West Sussex County Council - Planning Consultation Response

From: WSCC - Lead Local Flood Authority

LPA Reference: WA/61/26/PL

Recommendation: Objection

TITLE:
Post-Development Impermeable Areas.

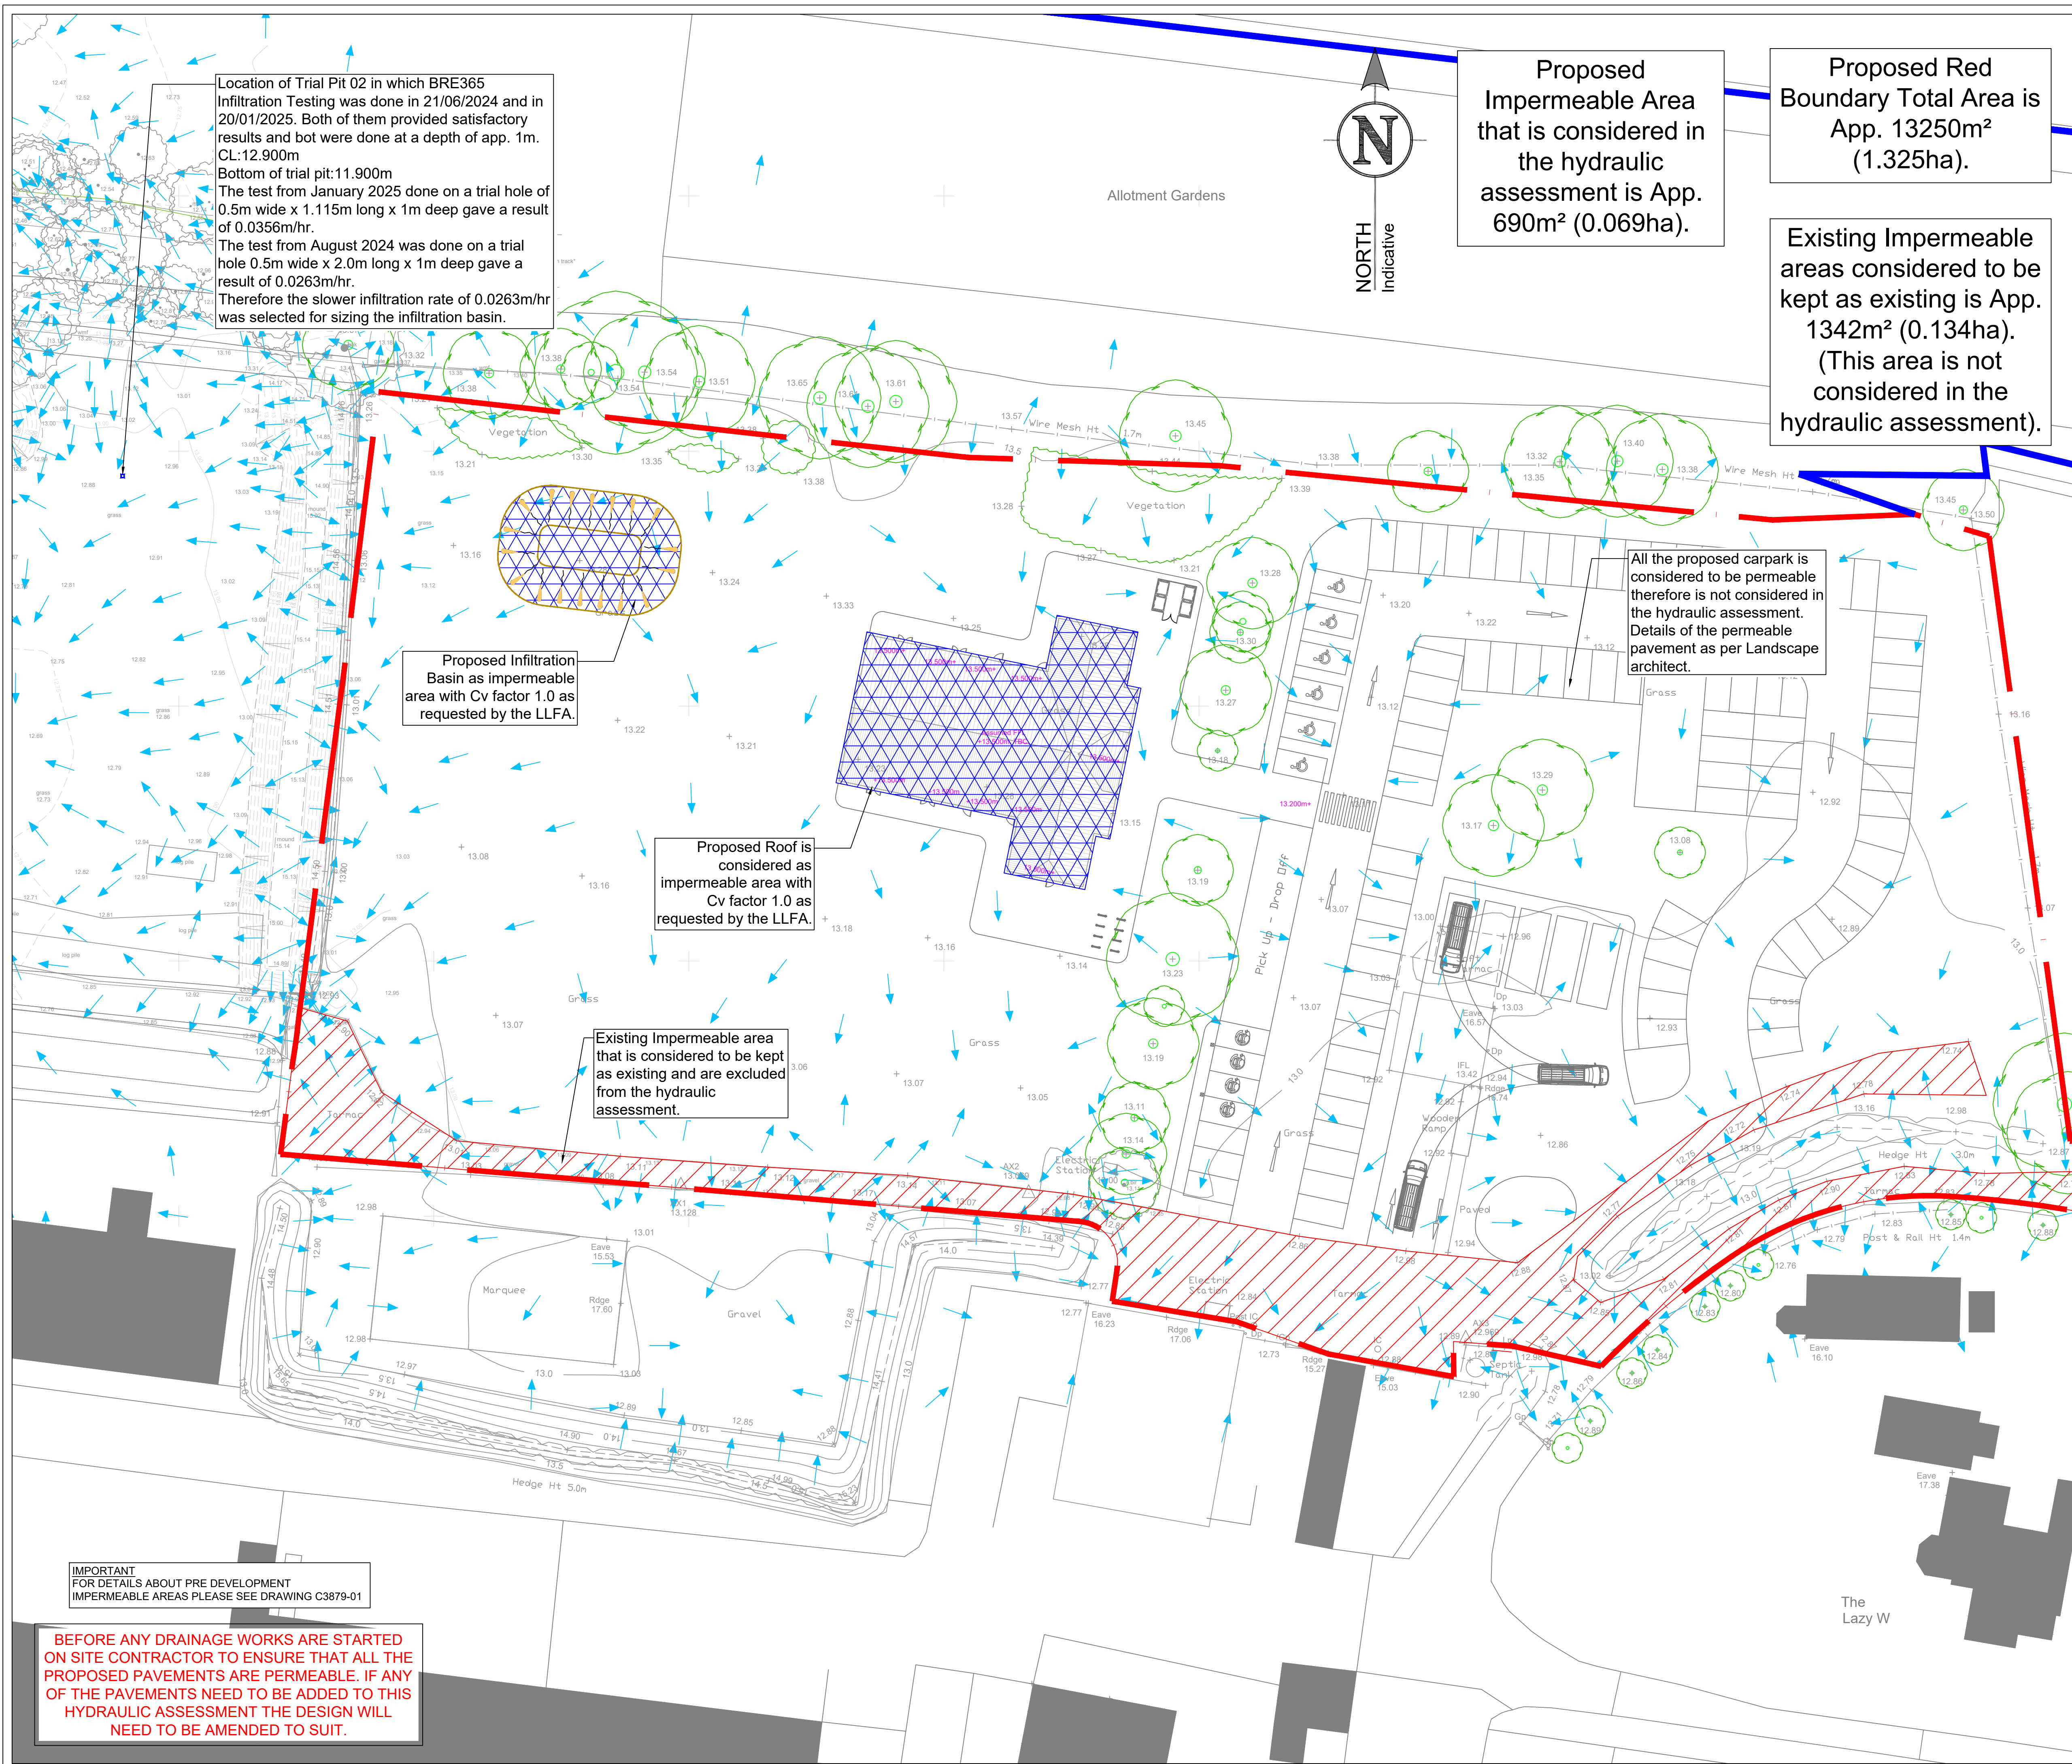
- The suitability of the site for infiltration through provision of BRE365-compliant infiltration testing.
- Groundwater conditions and any potential impacts on infiltration performance.
- Greenfield runoff rates and confirmation that post-development runoff will appropriately replicate the existing greenfield response.
- Drawdown performance of the proposed infiltration features.
- Safe management of exceedance flows during events exceeding the design standard.
- Clarification of hydraulic model outputs indicating surcharge and/or flood risk conditions within parts of the proposed drainage network.
- Compliance with the drainage hierarchy through a clear supporting assessment.
- Provision of an appropriate water quality treatment train.
